# LOI Redlines.pdf Markup Summary 7-28-2020

This is a stand alone application. The existing WSEO is a X and the request is amendment for XYZ; this file number is WSEO201

# WIND/SOLAR ENERGY GENERATION OVERLAY (WSE-O) PLAN (WSEO-17-001) FOR THE FRONT RANGE-MIDWAY SOLAR PROJECT

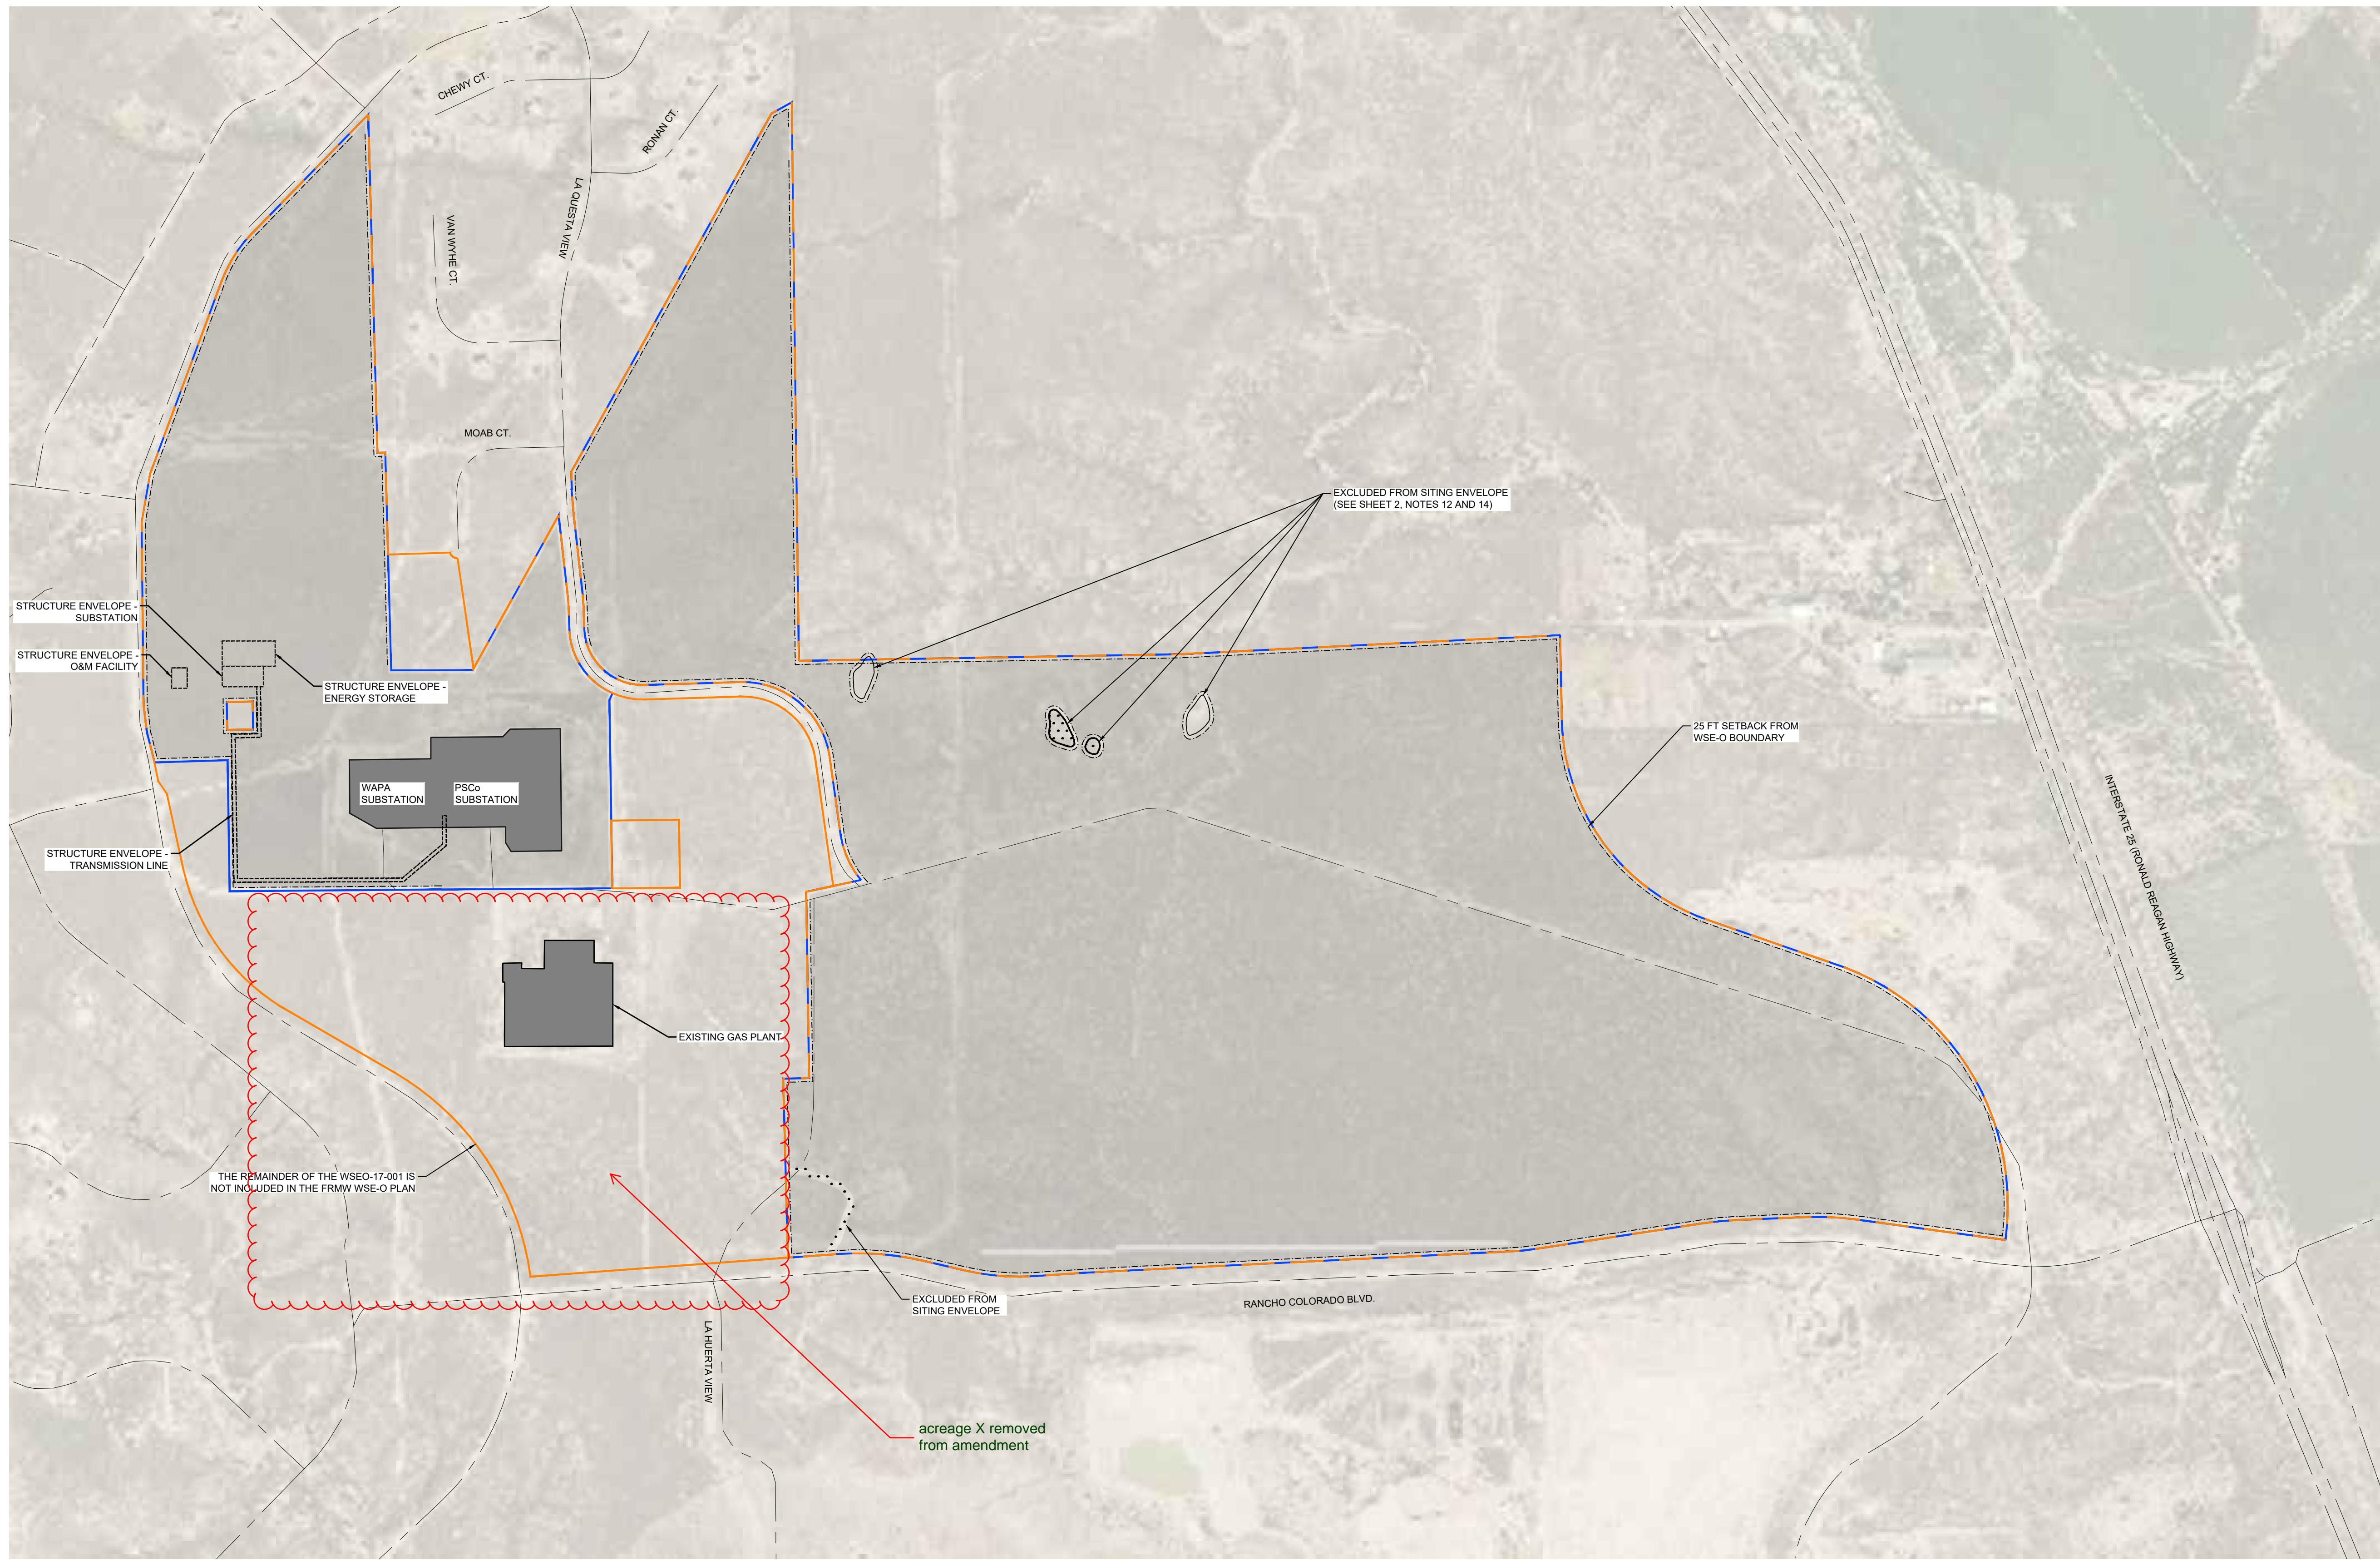
i recommend putting a snap shot of the WSEO approved solar array envelope and boundary and what is proposed...

i thought the acreage decrease as stated above. Please clarify above- the map boundary requested to be inserted of approved WSEO and proposed will help clarify

**TRANSMISSION LINE POLE ELEVATION**  
SCALE: N.T.S.  
LOOKING AHEAD

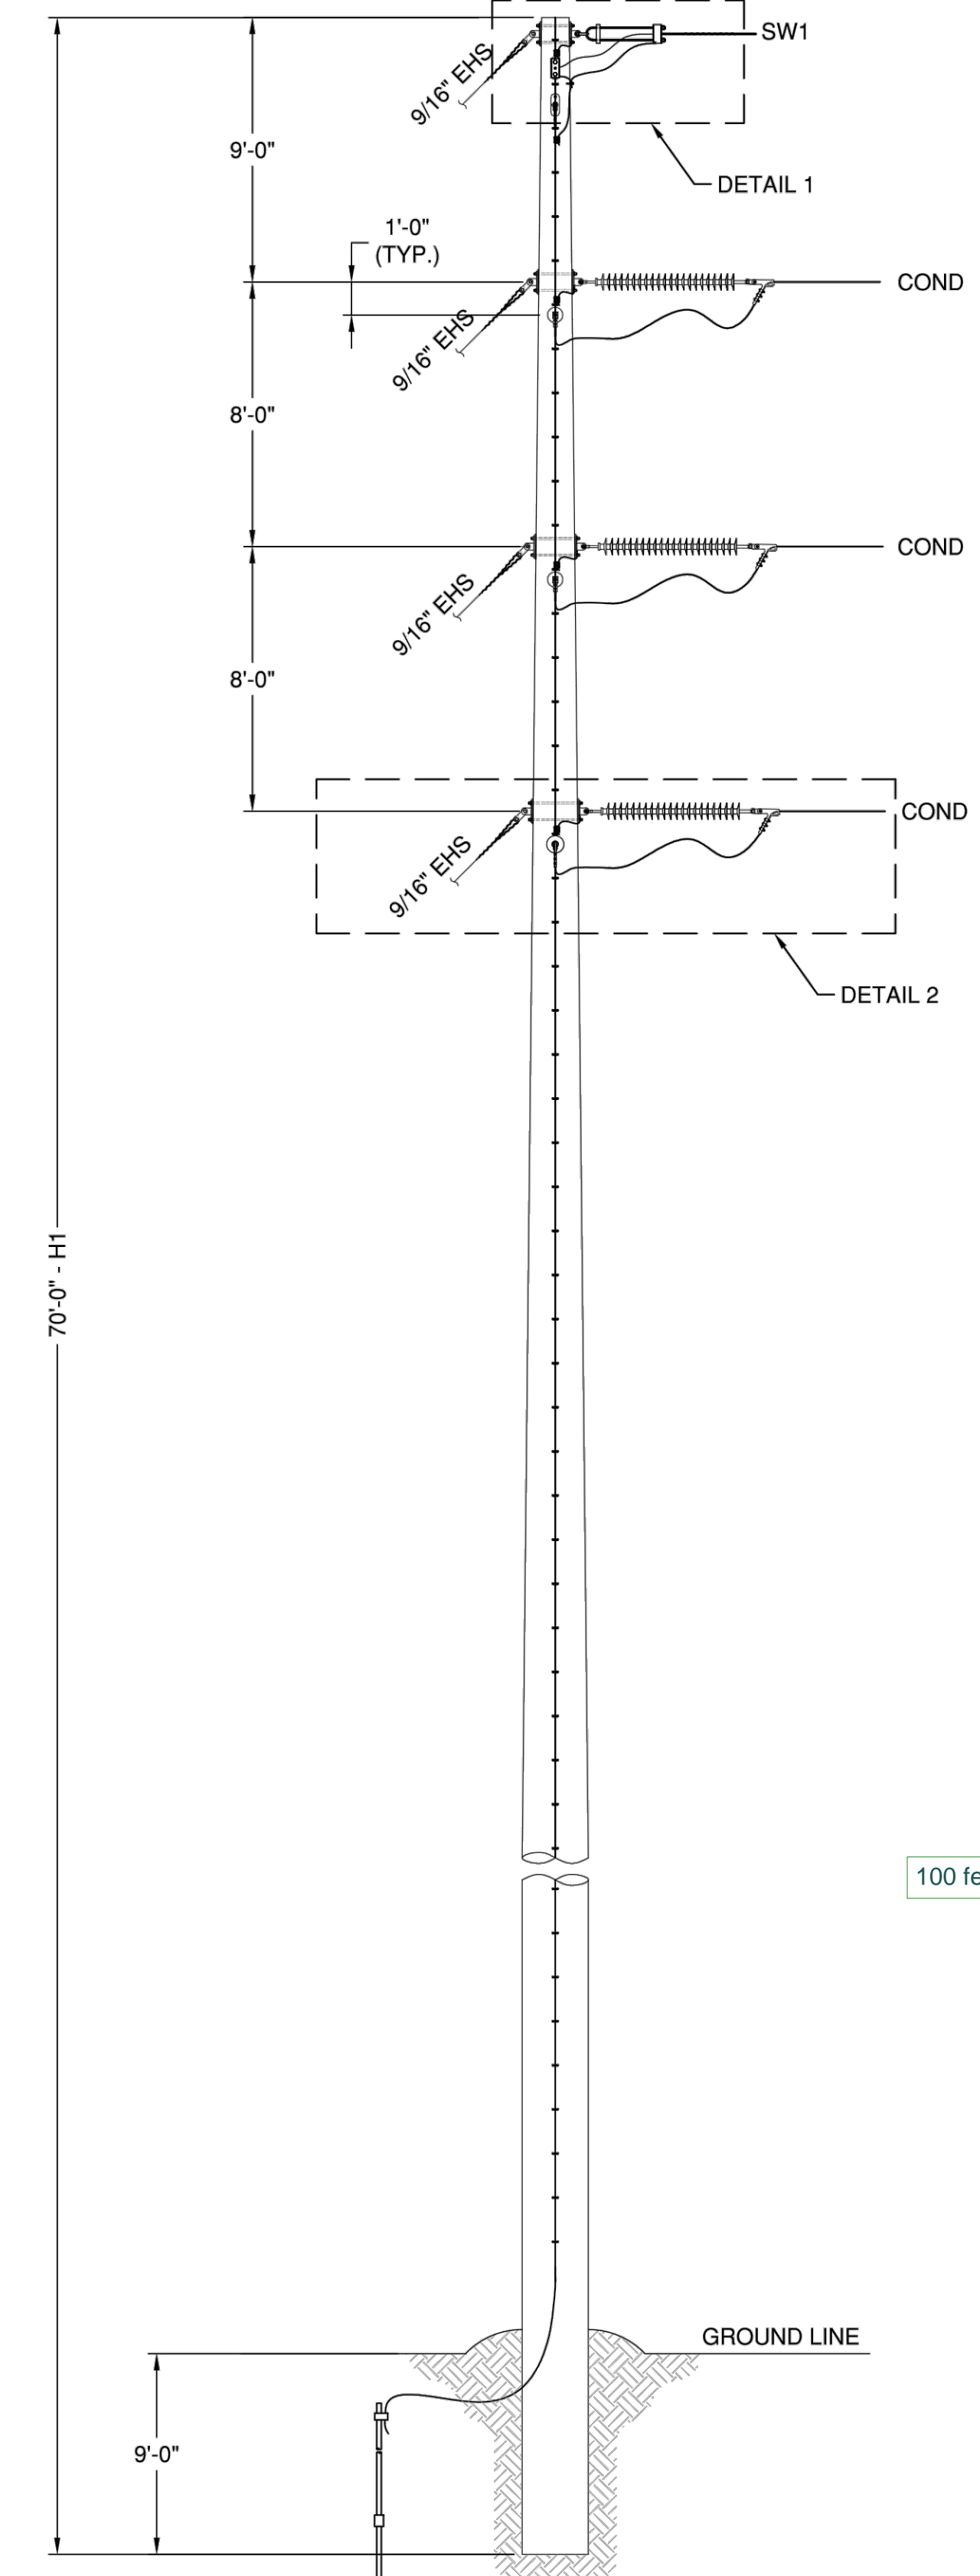
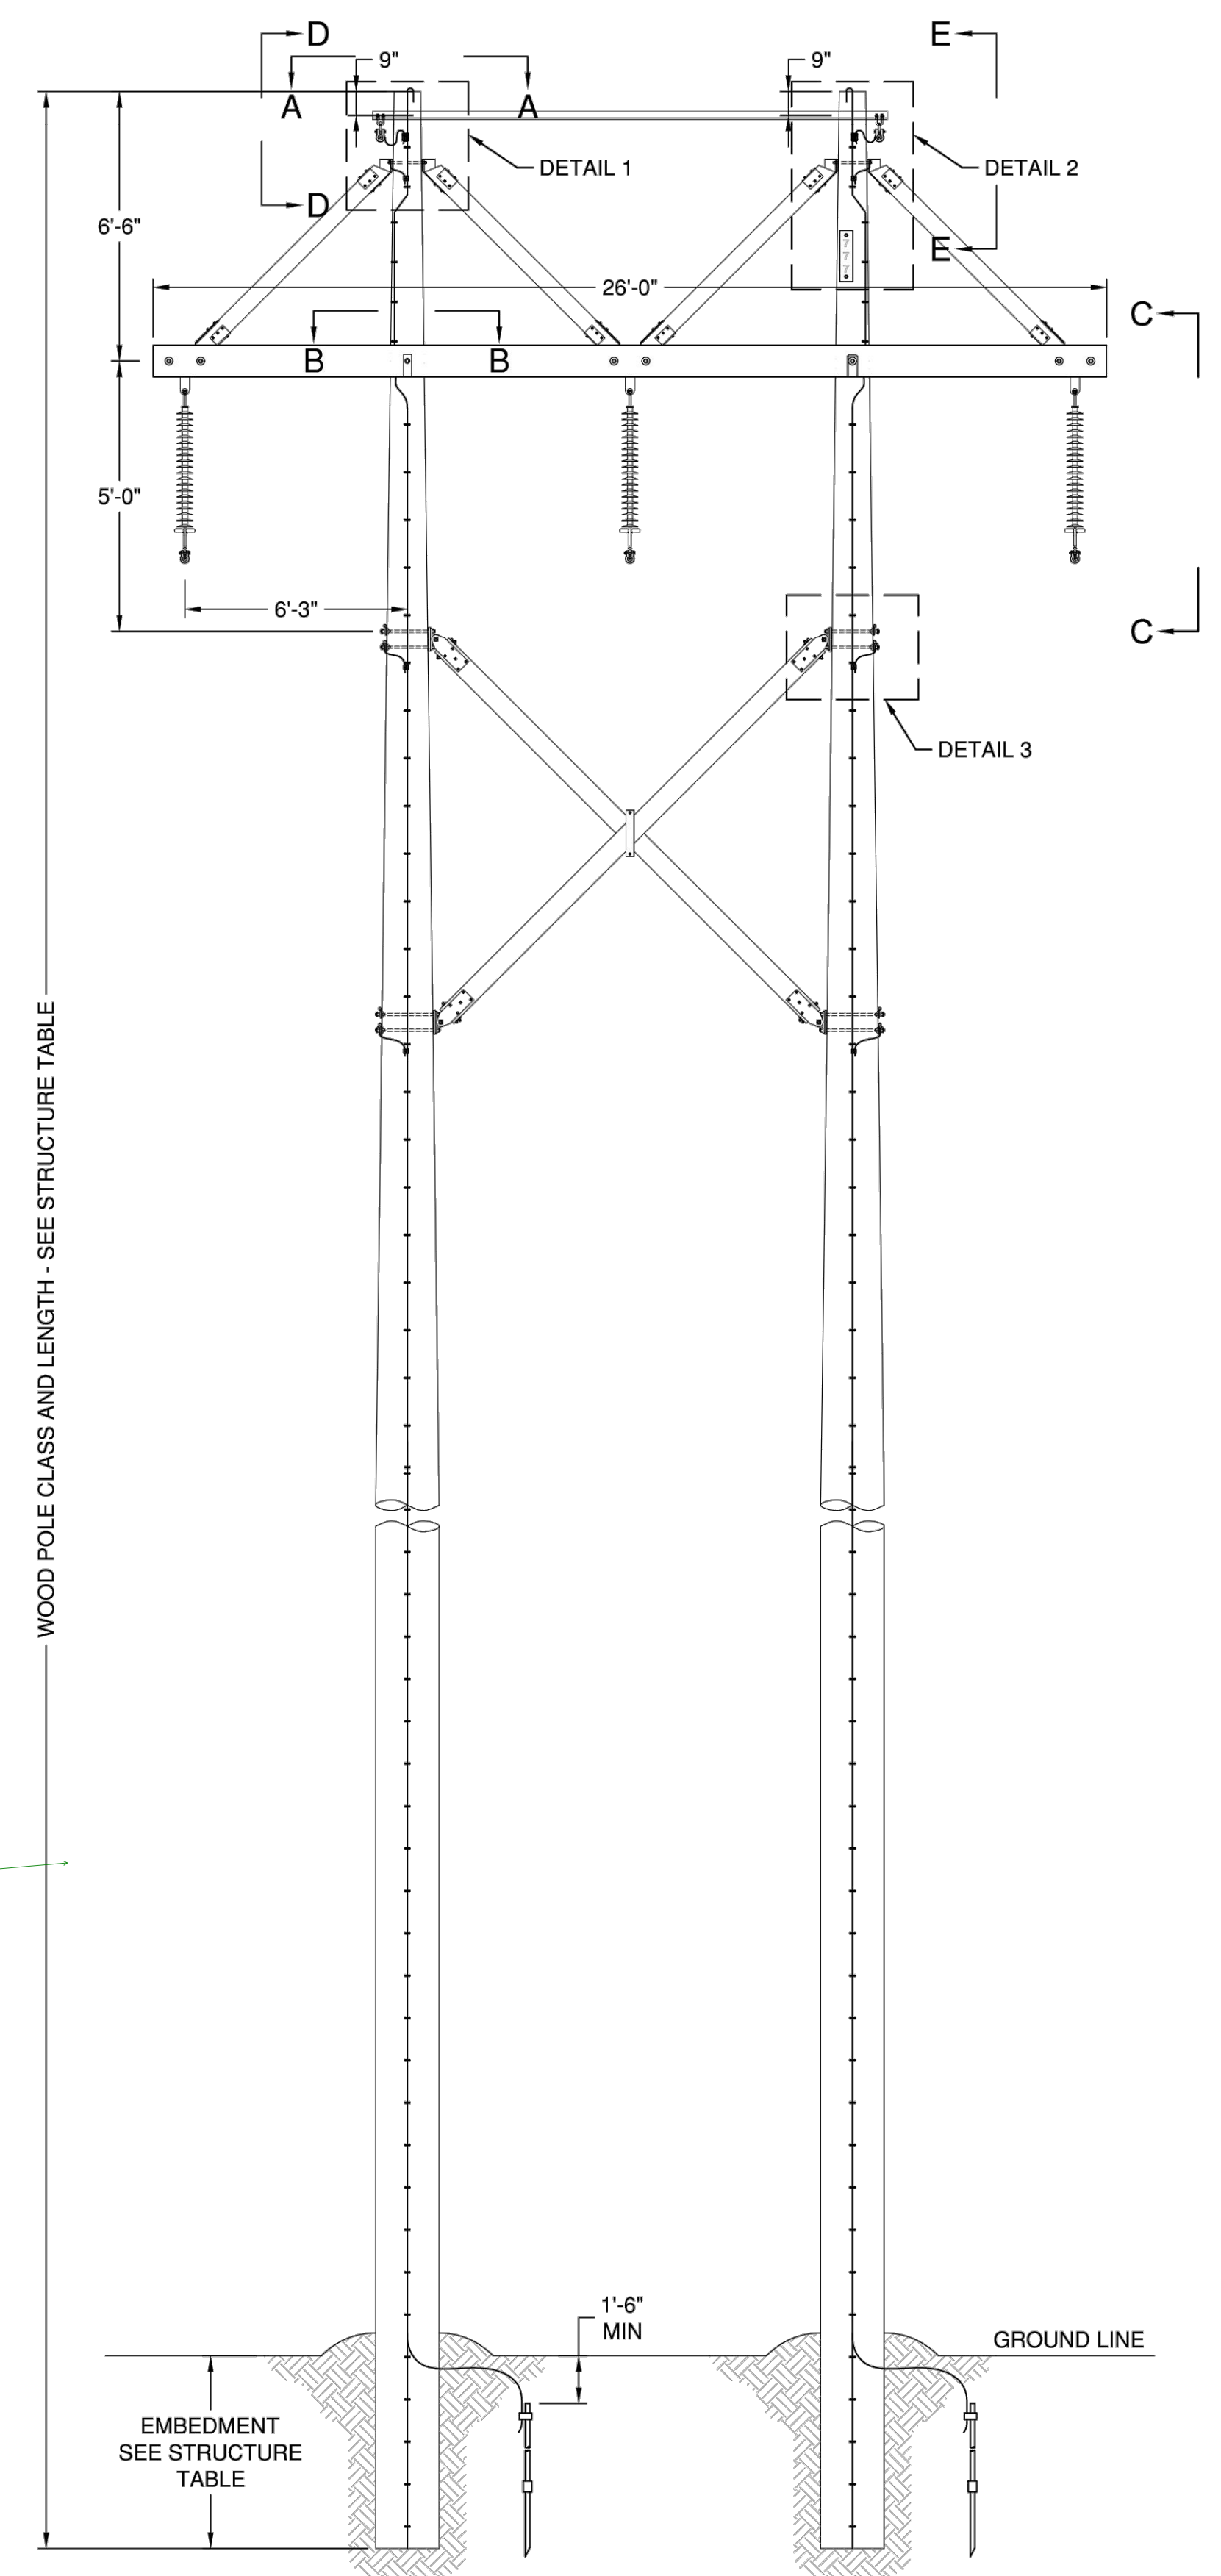
so your asking for a total height of X for each?

do they support the new heights?
